Your Ref SSD-84348959
Our Ref NCA/15/2025
Contact Alex McDougall
Telephone 9806 5998
Email amcdougall@cityofparramatta.nsw.gov.au

COUNCIL SUBMISSION TO EXHIBITION OF 'MELROSE PARK GATEWAY' DEVELOPMENT (CORNER OF HOPE STREET AND HUGHES AVENUE, MELROSE PARK)

APPENDIX 1 – DETAILED OBJECTIONS/COMMENTS

Source: Turner Studio, Drawing No: DA-110-010, Rev A, 21/07/2025, GA Plans Level 01

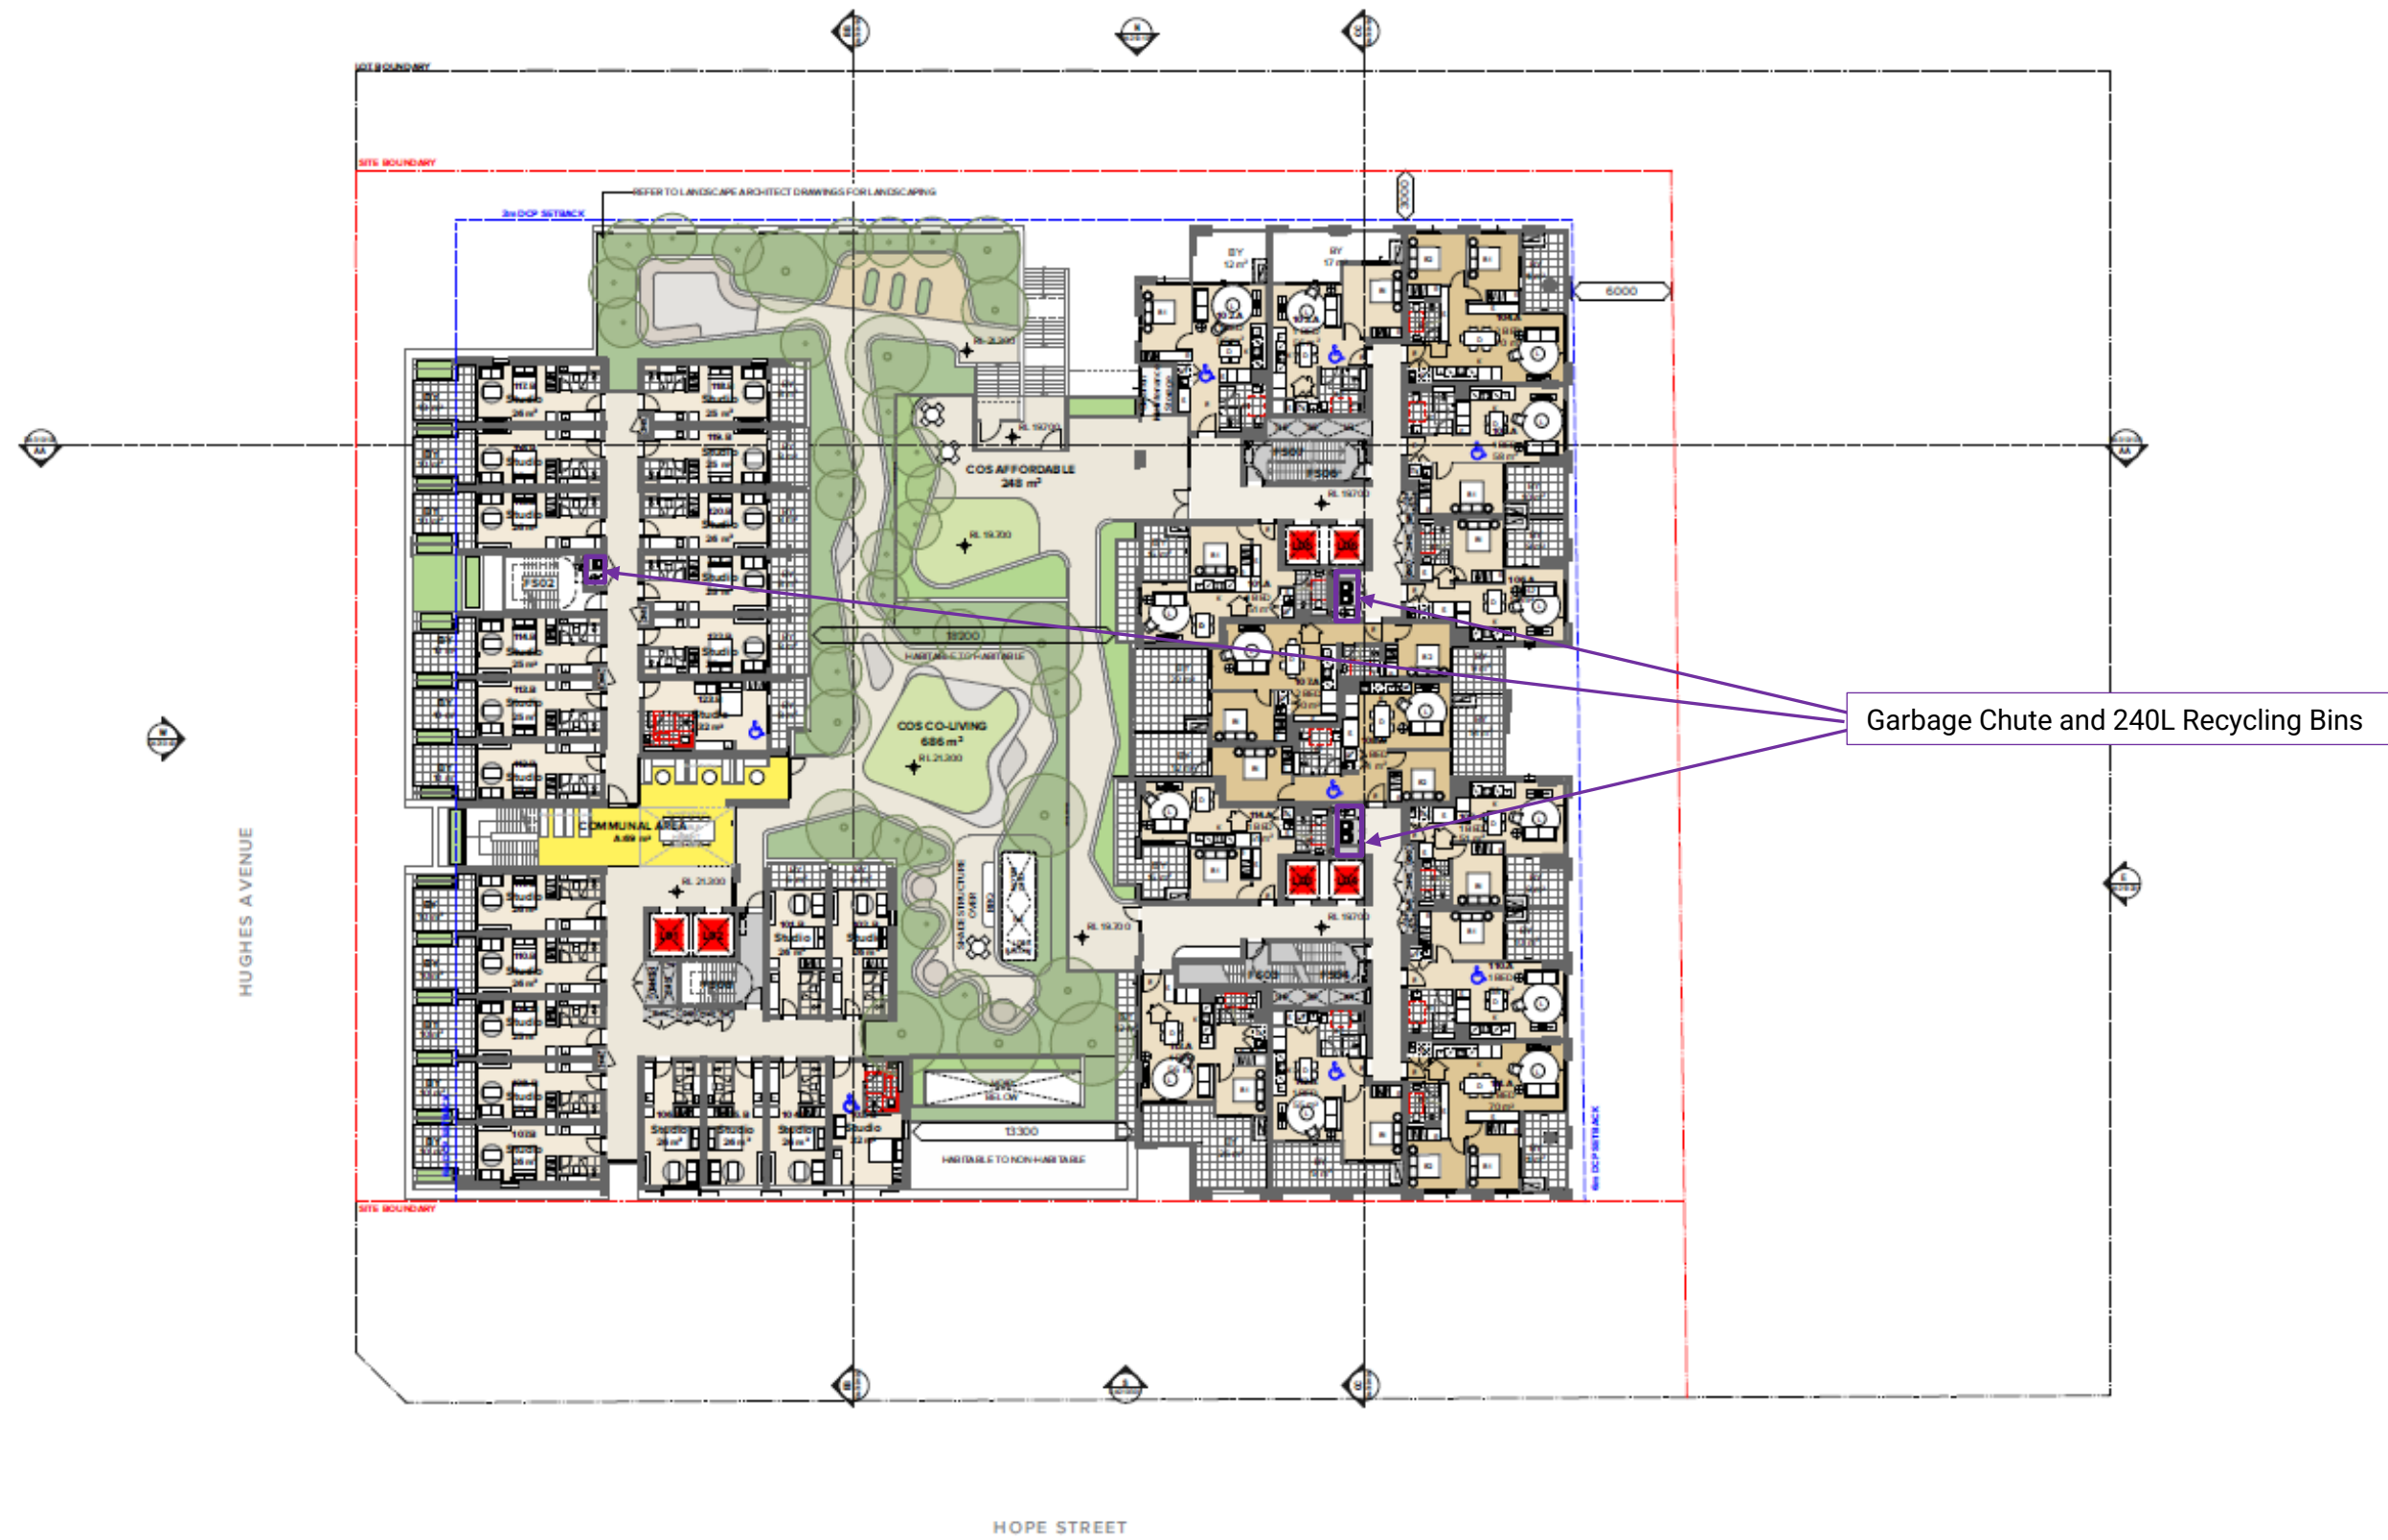
- The separation between towers is 13.3 metres and 18.2 m resulting in one poorly proportioned shared courtyard between the towers.
- On Level 01 the COS for Co-living located in the western part of the courtyard is separated by a barrier of levels / planting running north/ south from the COS for Affordable Housing. Because the spaces are narrow and linear the amount of useable area is limited by the planting against the private balconies and the access paths through the spaces. The courtyard on level 01 is deficient in useable outdoor space as it:
 - Separates the COS for the co-living residents from the affordable housing residents.
 - Has all landscaping in planters at RL21.3, 600mm above the courtyard level and located above the basement. This further limits at grade activities.

- Creates two long narrow spaces with entry paths thereby minimising adequate useable area for COS.
- Is two storeys above the ground and does not provide views to and from the pedestrian pathway on the north.
- Enables overlooking from the northern end of the courtyard into the rear garden of neighbouring Hughes Avenue properties.

The co-living communal open space ('COS') and the affordable housing COS are located within the central plaza but have been segregated by a 1.6m level difference (plus a 1m high planter to the upper level = 2.6m retaining wall). Access between the two spaces is through a flight of stairs, or a convoluted route through the basement, loading dock and lifts. The affordable COS portion of the space is oppressive with limited useable spaces provided. It is

mainly a circulation corridor and does not meet the ADG requirements. The split-level design exacerbates the narrow layout leading to poor design, narrow planting beds, small gathering spaces and insufficient privacy and amenity to the adjacent private open spaces ('POS').

The COS on level 01 is to be redesigned to ensure it meets the ADG requirements design objectives and guidelines as described in Part 3D of the Apartment Design Guide (ADG) for all to benefit and enjoy.

As a minimum, the level 01 communal open space (co-living and affordable) must be designed as one, integrated space including equal access across the courtyard. It is to be designed to be attractive and inviting, have a variety of useable spaces with a range of passive and active functions, including opportunities for various groups sizes and individual recreation, direct solar access and incorporate direct and equal access to the communal open spaces from common circulation areas, entries and lobbies.
